COUNTY COUNCIL'S RESPONSE TO CONSULTATION ON THE FOLLOWING DEVELOPMENT PROPOSAL

Application No: 18/01333/F-2

Proposal: Extension to existing Technical Site to provide new employment units comprising flexible B1(c) light industrial, B2 (general industrial), B8 (storage or distribution) uses with ancillary offices, storage, display and sales, together with associated access, parking and landscaping.

Location: Bicester Heritage, Buckingham Road, Bicester.

Title **Drainage Layout Sheet 1 of 2**

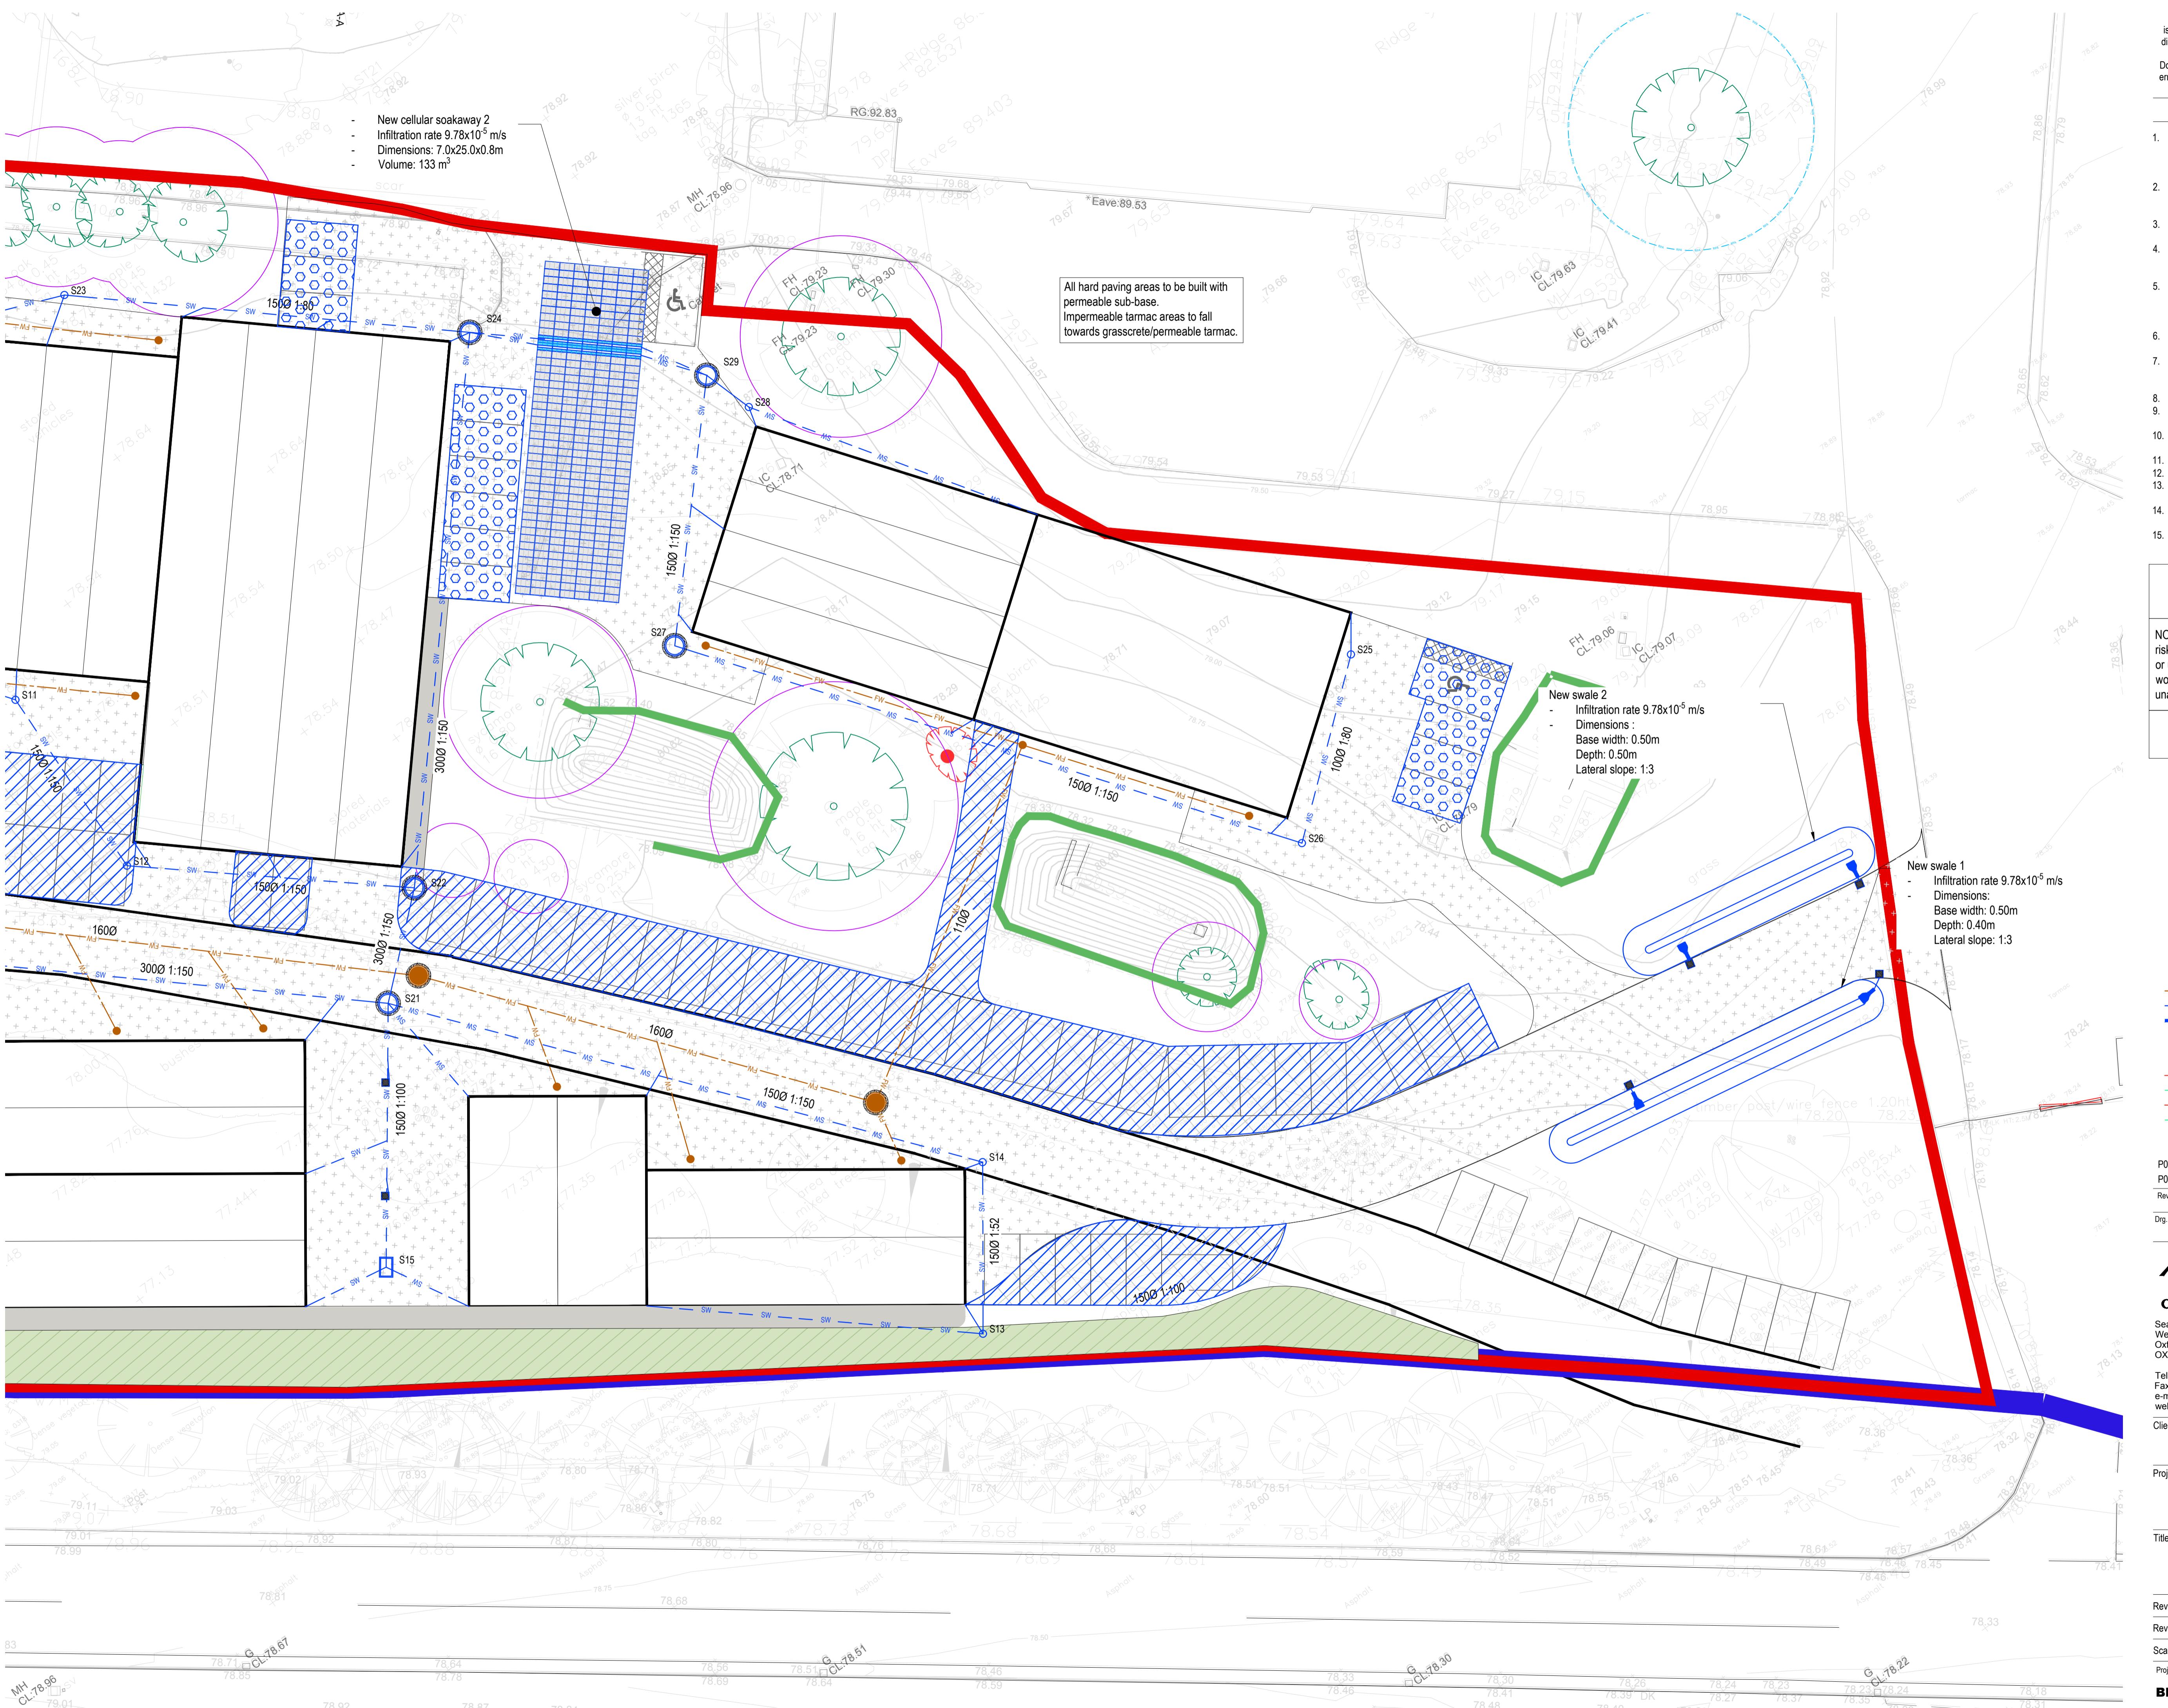
The Applicant has provided an updated drainage strategy for the site by AKS Ward Consultants dated October 2018. It is proposed to use swales, permeable paving and infiltration soakaways to manage surface water for flows up to the 100 years storm event (plus allowance for Climate Change) on the site through infiltration to ground. Two factors that could affect the drainage design include the level of the ground water at the site and the presence of contamination in the ground.

The seasonal high ground water level should be established through ground water monitoring at the site to demonstrate that a one-meter minimum clearance can be maintained between the base of the infiltration device and the high groundwater level. OCC (Drainage) requires additional assurances on the steps that will be undertaken, demonstrating that the use of infiltration devices will not mobilize contamination. Details of the scheme of soil / leachate sampling investigation that will be undertaken at the base of and surrounding vicinity of any proposed infiltration device, to test for contaminants to ensure any contamination present in the soil is not mobilised by the use of the devices, must be provided. The scheme must describe details of the type, frequency, likely contamination suites, of the proposed testing at the site. Following testing details of appropriate mitigation must be provided. These requirements can be secured by use of a condition if planning approval for the site is gained.

The Flood Risk Assessment conclusion states that: *“There is a surface water flow-path within the south site which will need to be maintained. Incorporating a conveyance channel along the south west boundary before discharging to the existing ditch would provide this opportunity.”* Although the applicant provided an exceedance

flow plan for the site it was unclear whether this addressed the point picked up in the Flood Risk Assessment about the need for a “*conveyance channel along the south west boundary*”. Therefore, this point requires further clarification and Flood Exceedance routing may require additional detailed design after final site levels are determined, which must form part of a condition.

Development shall not begin until a surface water drainage scheme for the site, based on sustainable drainage principles and an assessment of the hydrological and hydro-geological context of the development, has been submitted to and approved in writing by the local planning authority. The scheme shall subsequently be implemented in accordance with the approved details before the development is completed. The scheme shall also include:

- Infiltration to BRE 365 (Seasonal monitoring of groundwater levels at the site)
- SUDS (Swale, Underground Geo-Cellular Soakaway, Permeable Paving)
- Maintenance and management of SUDS features (To include provision of a SuDS Management and Maintenance Plan)
- Detailed drainage layout with pipe numbers
- Network drainage calculations
- Flood Flow Routing in exceedance conditions
- To prevent any potential contamination of groundwater, details of a scheme of soil/ leachate testing below and within the vicinity of any infiltration device
- Details of any mitigation that is required to prevent contamination to groundwater below or surrounding any proposed infiltration device (after soil / leachate testing)
